**From:** tim and jan treacher  
**Sent:** 10 February 2021 22:04  
**To:** Planning  
**Subject:** Application 21/00037/LBC

**OXFORD CIVIC SOCIETY: COMMENT ON PLANNING APPLICATION**

*21/00037/LBC | Proposed change of use to first and second floors from Hotel (Use Class C1) to 3no. apartments ( 2no. residential (Use Class C3) and 1no. House in Multiple Occupation (Use Class C4)). Internal alterations. | 107 St Aldate's Oxford OX1 1BU*

DRAWING: PROPOSED FIRST AND SECOND FLOOR PLANS

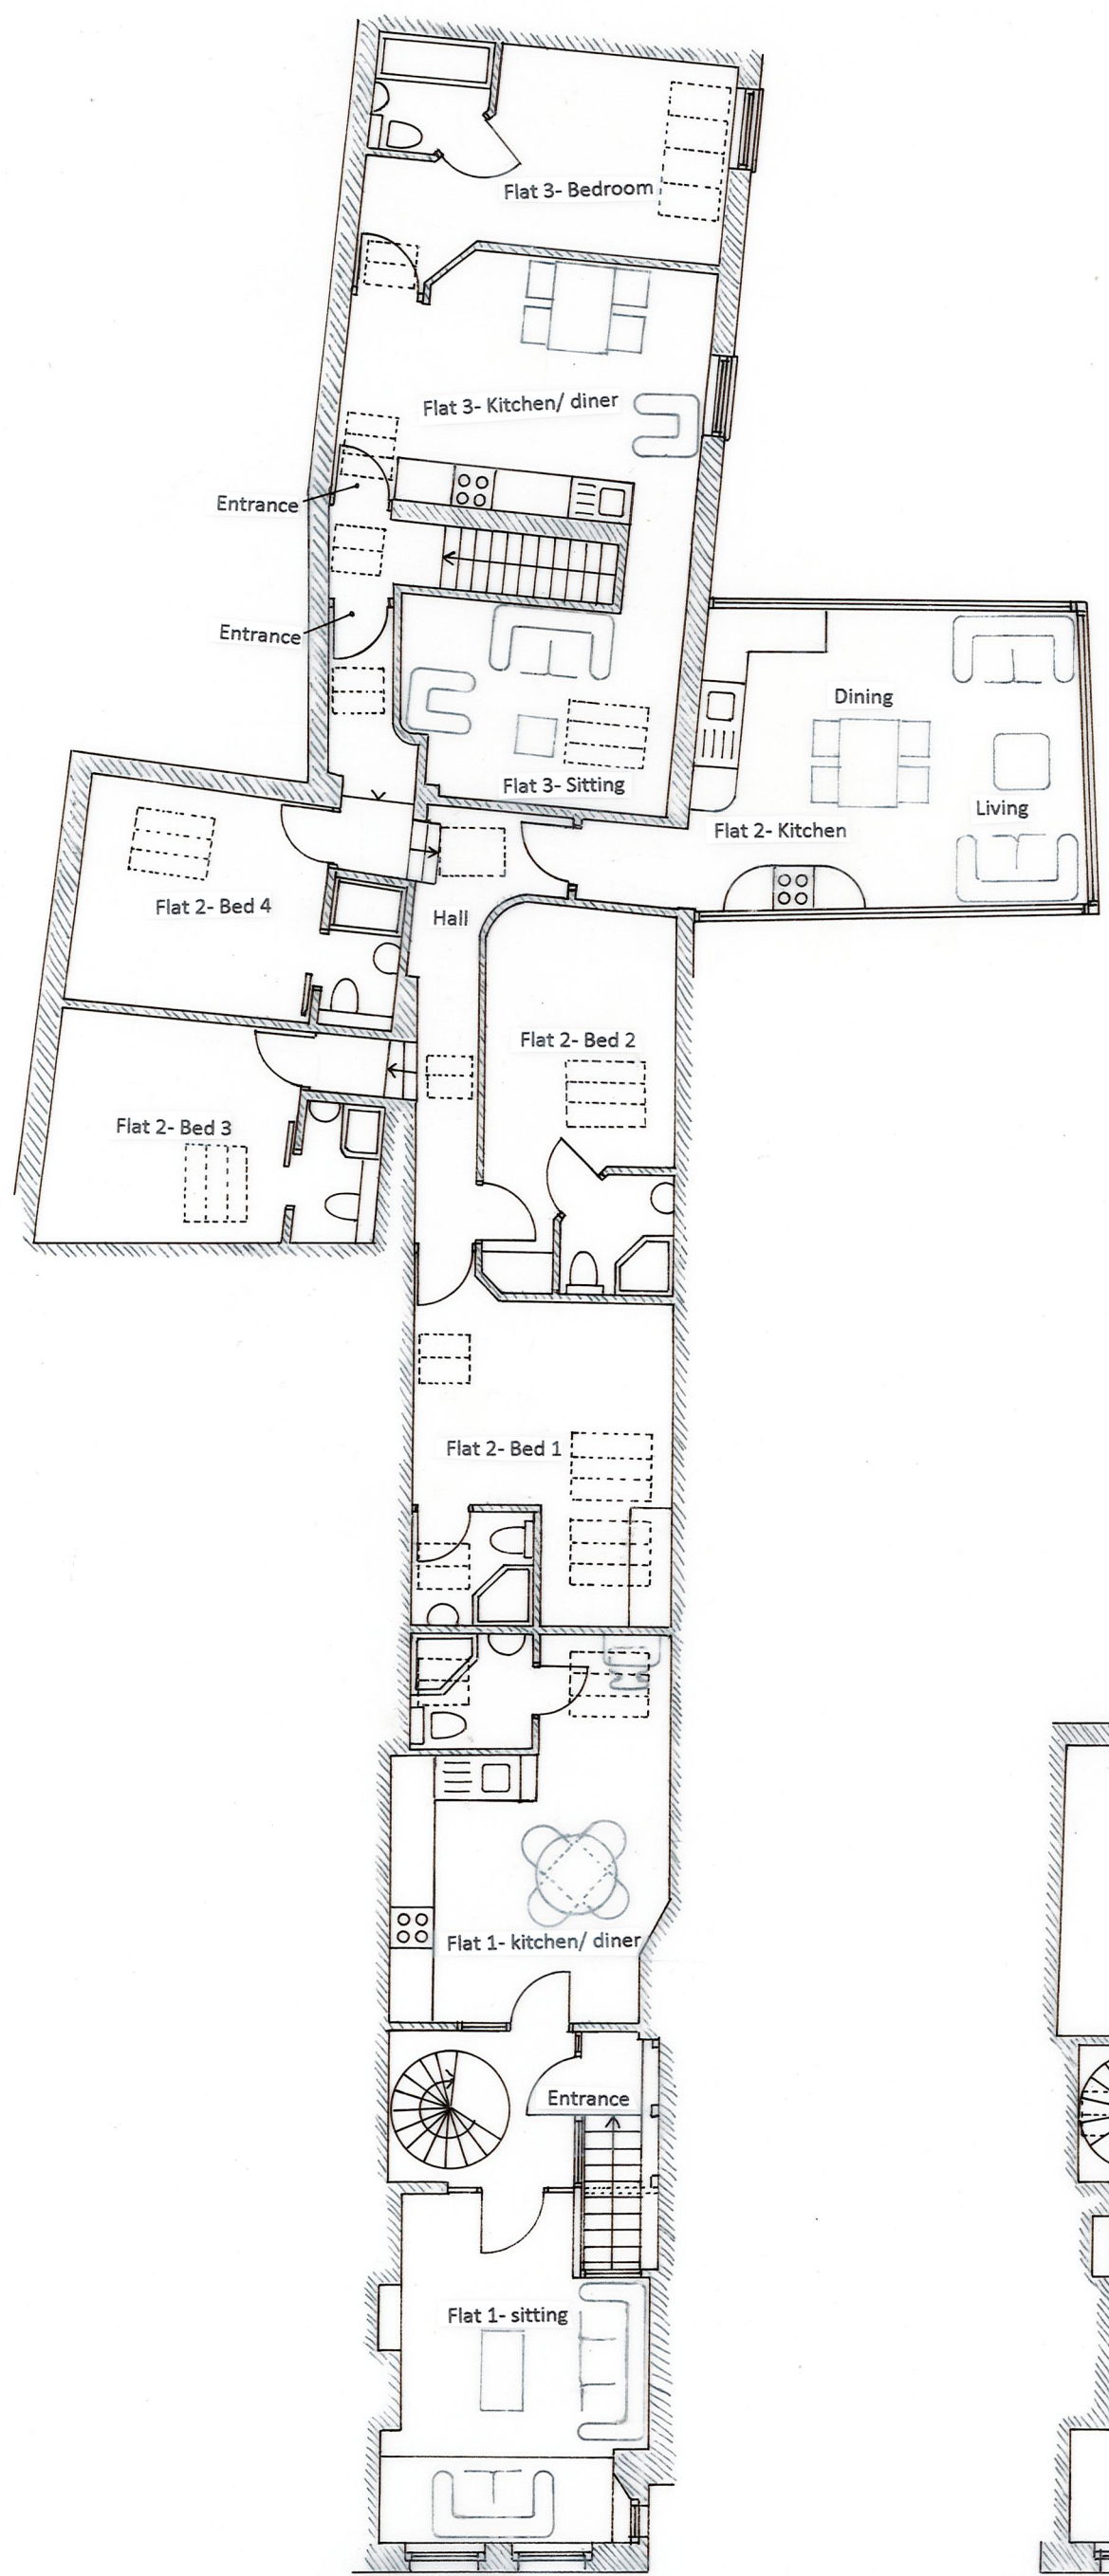
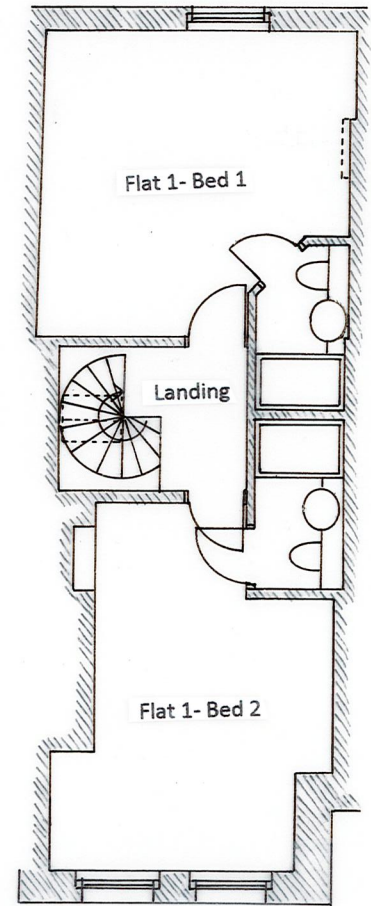
The very strange configuration of this Grade 2 listed property does not lend itself well to the proposed change to residential use. The windowless rooms are arguable acceptable for short stay hotel guests but not for long term residents. It is also unclear how what would become party walls between adjacent apartments would be dealt with. There are no explanations for this.

The part of the proposal which would create an HMO is also defective in the inadequate provision for cycle parking and for the management of refuse and recycling.
